TR010064: Application by National Highways for the M60/M62/M66 Simister Island Interchange Project

The Examining Authority's Written Questions and requests for further information

Issued on 22 October 2024

Drawing title
**LAND PLAN
REGULATION 5(2)(i)
KEY PLAN**

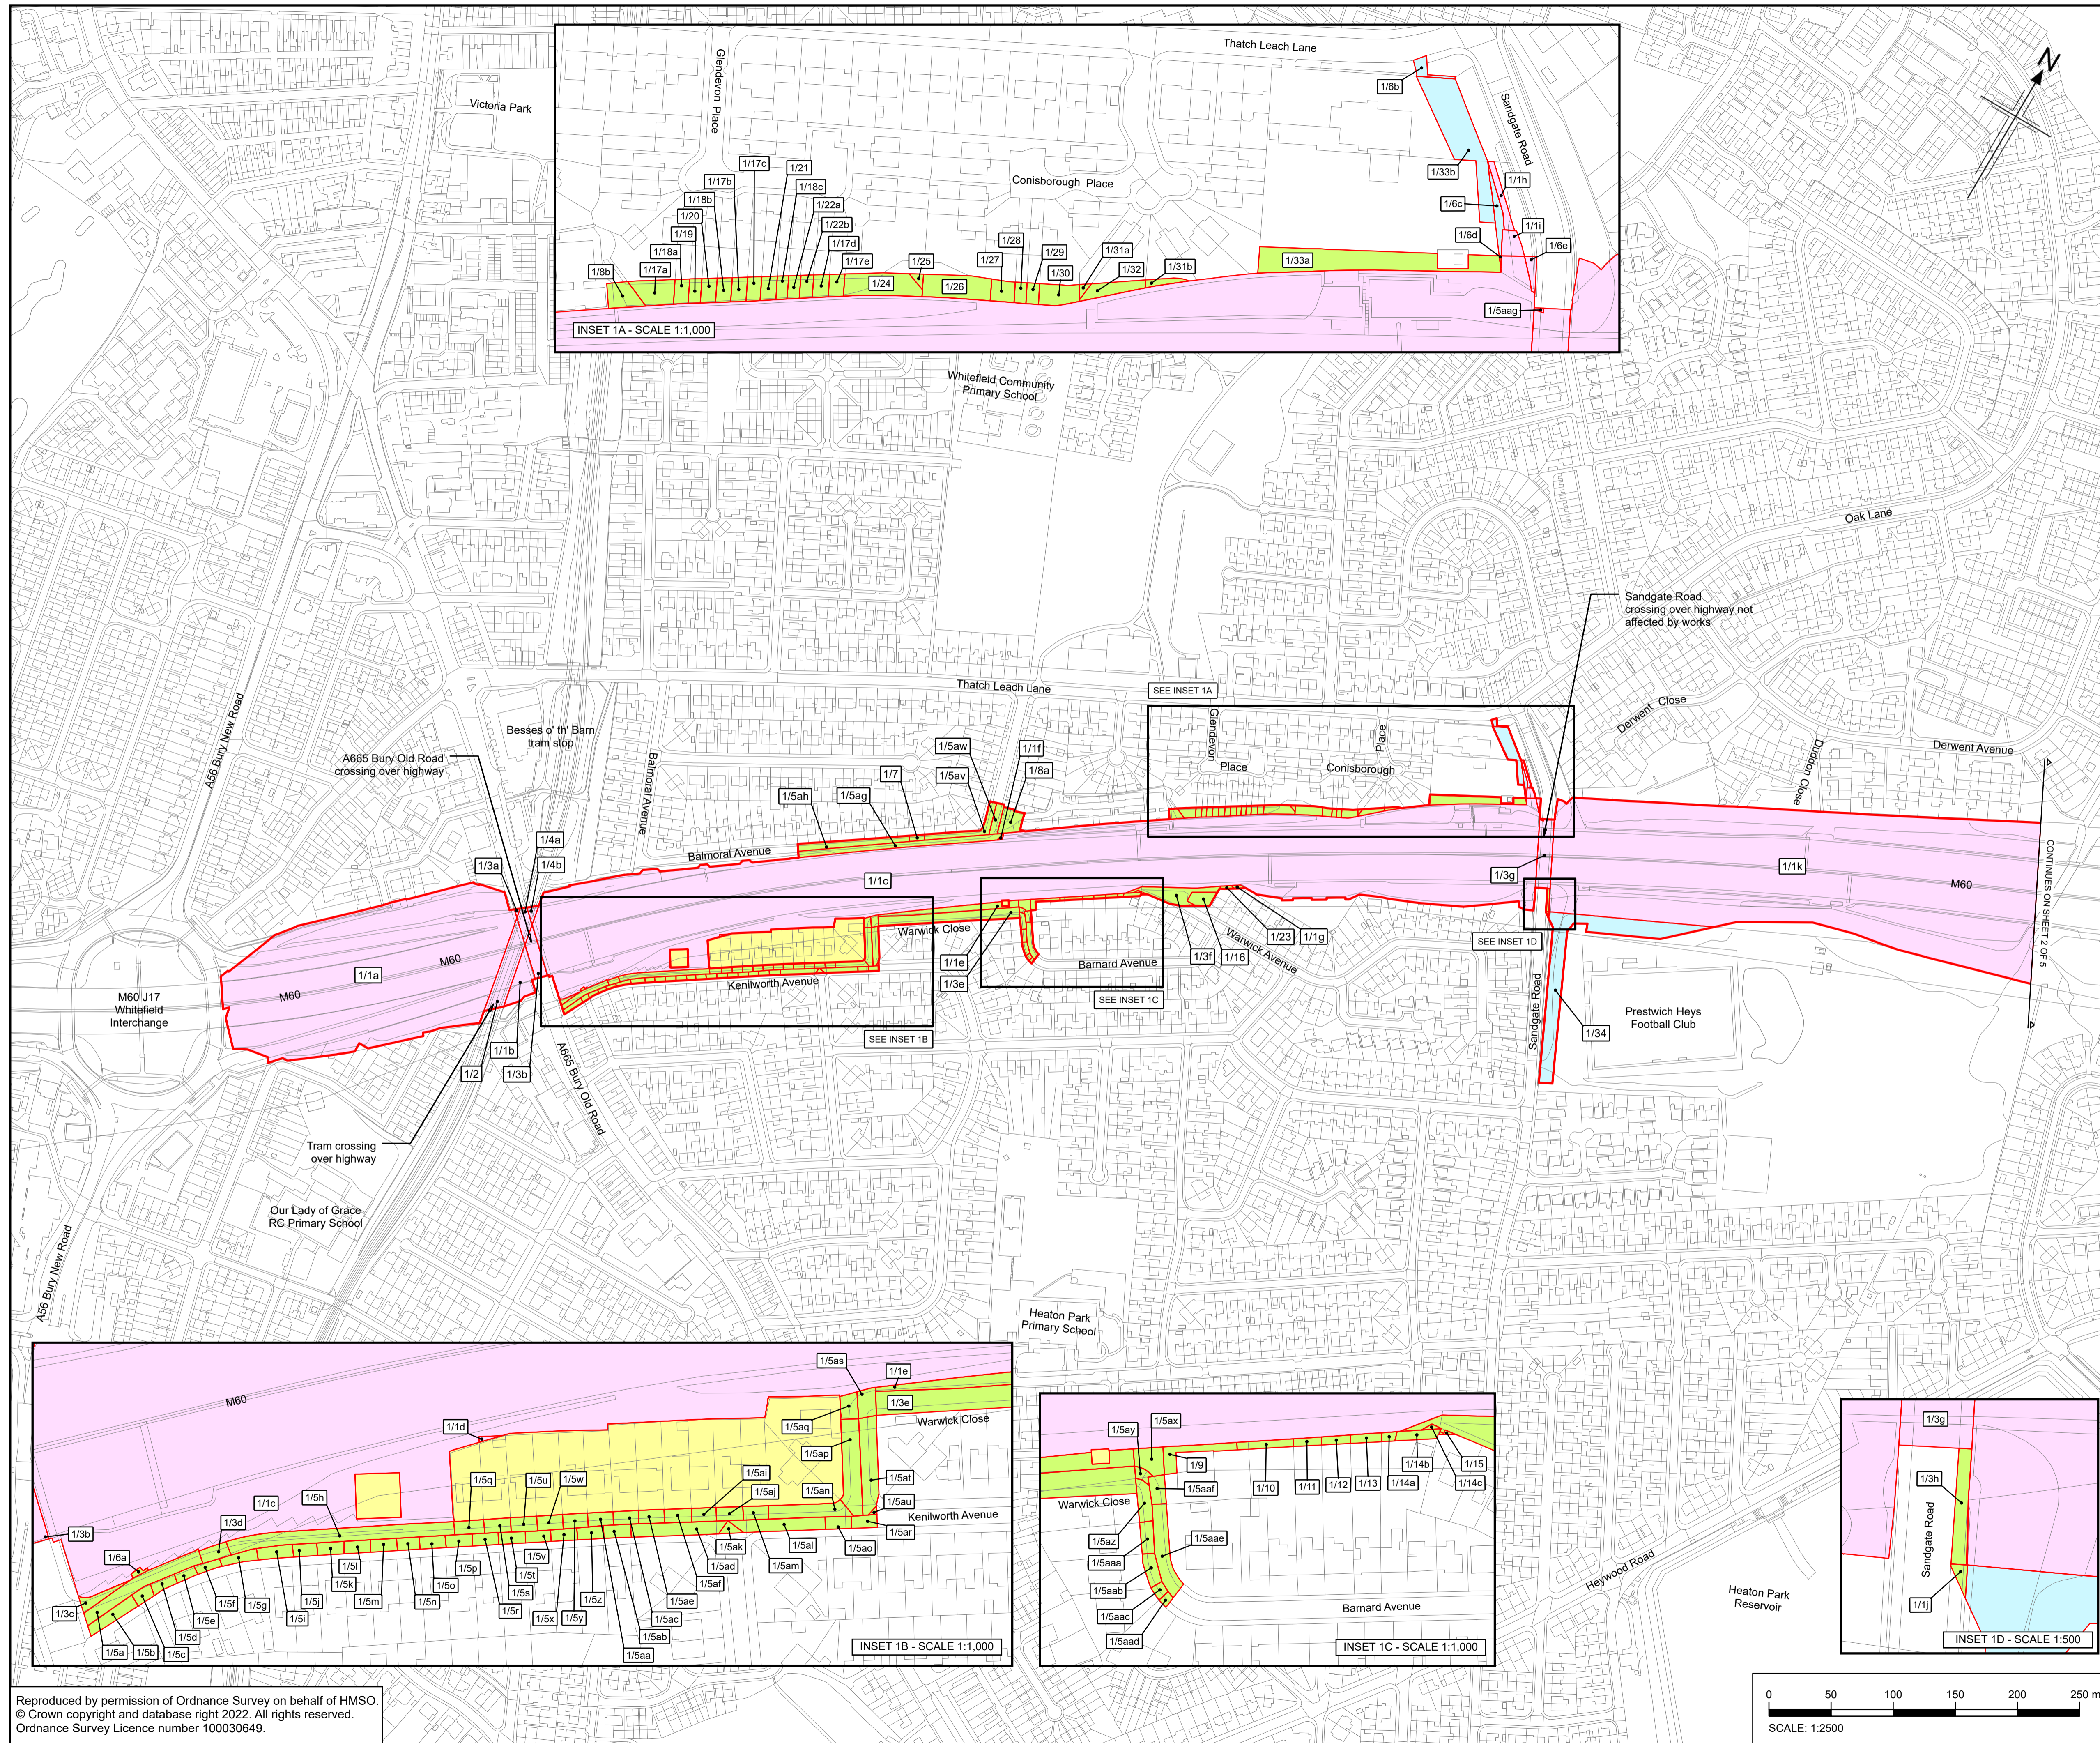
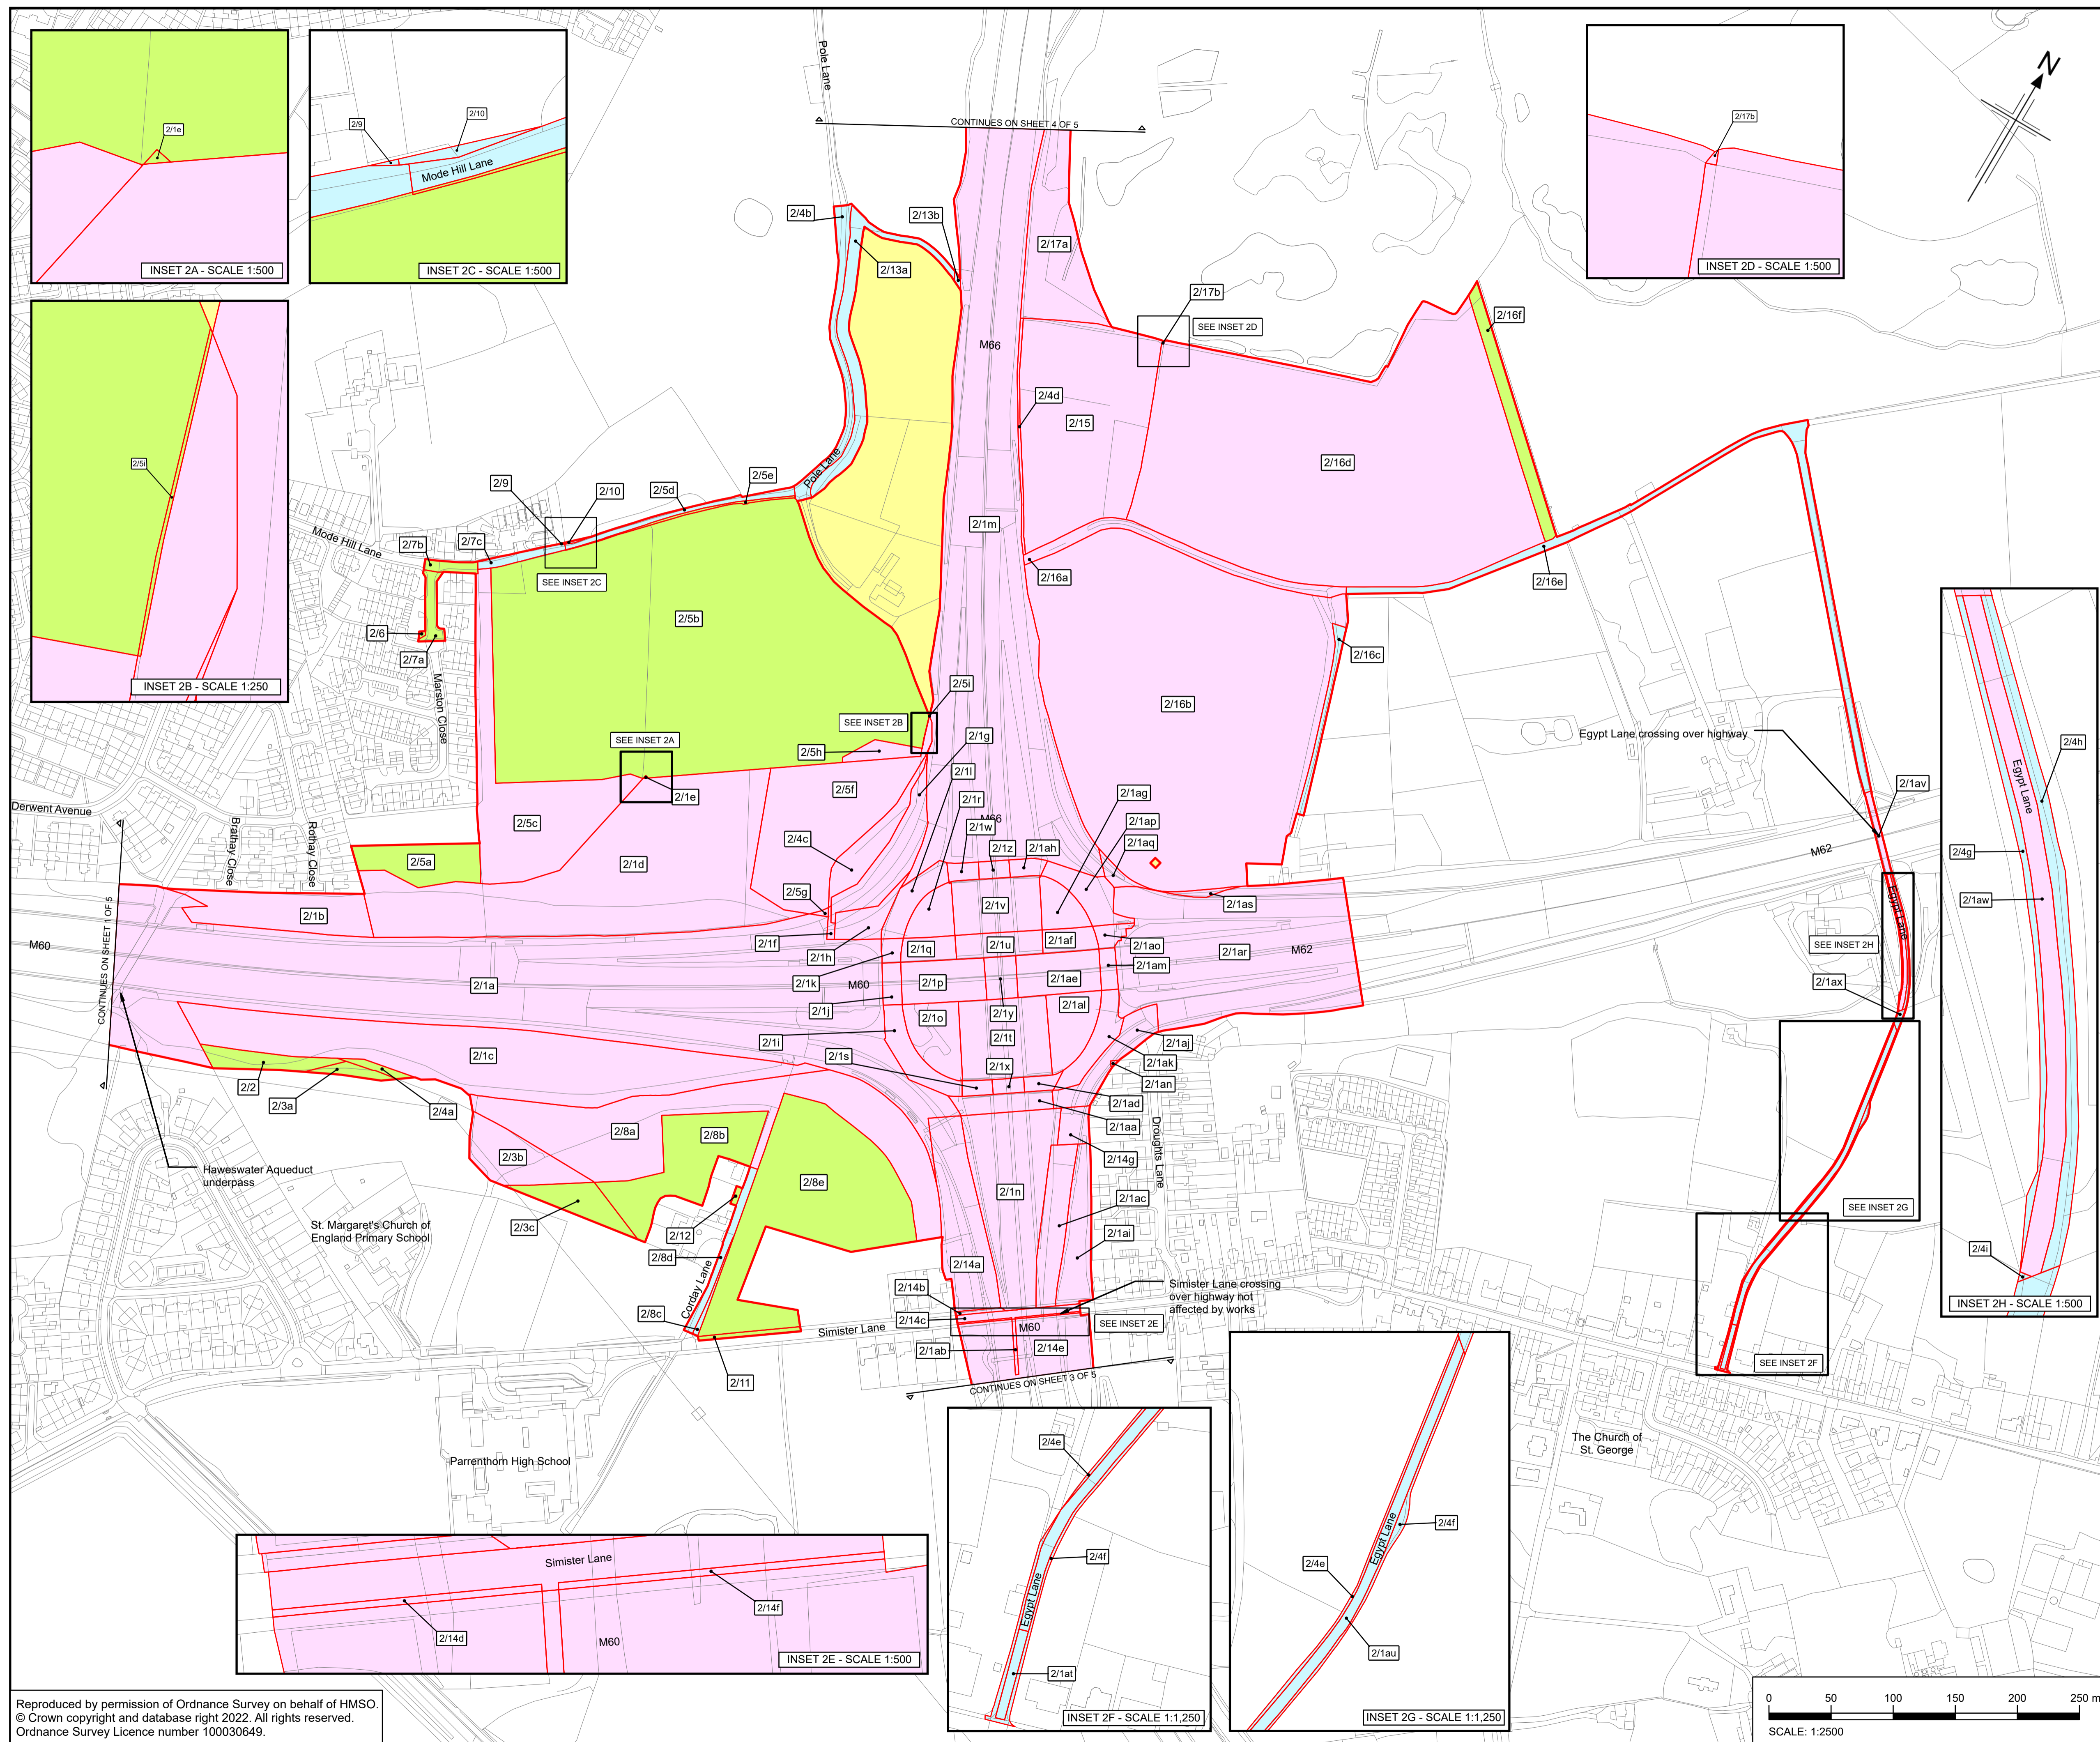
ExQ1	Question to:	Question
CA.1.2	Applicant	<p>Category 3 Persons</p> <p>The Statement of Reasons (SoR) [APP-019], Section 4.7 briefly covers the assessment of Category 3 persons explaining that it was based on a worse-case assessment. The process is described in the BoR [AS-010].</p> <ol style="list-style-type: none"> i. Please provide further details of the process for identifying Category 3 persons. ii. Please provide a map showing the locations of Category 3 persons. iii. Explain why the assessment can be considered 'worse-case'.
CA.1.3	Applicant	<p>Unknown/Unregistered Land</p> <p>Diligent enquiry into land interests: Could you summarise where you have not yet been able to identify any persons having an interest in the land, including any Rights over unregistered land? What further steps will you be taking to identify any unknown Rights during the Examination?</p>
CA.1.4	Applicant	<p>Land Plans</p> <p>There is no plot 3/3 but there are two plots marked 3/4 on the Land Plans [AS-005]. Please correct.</p>
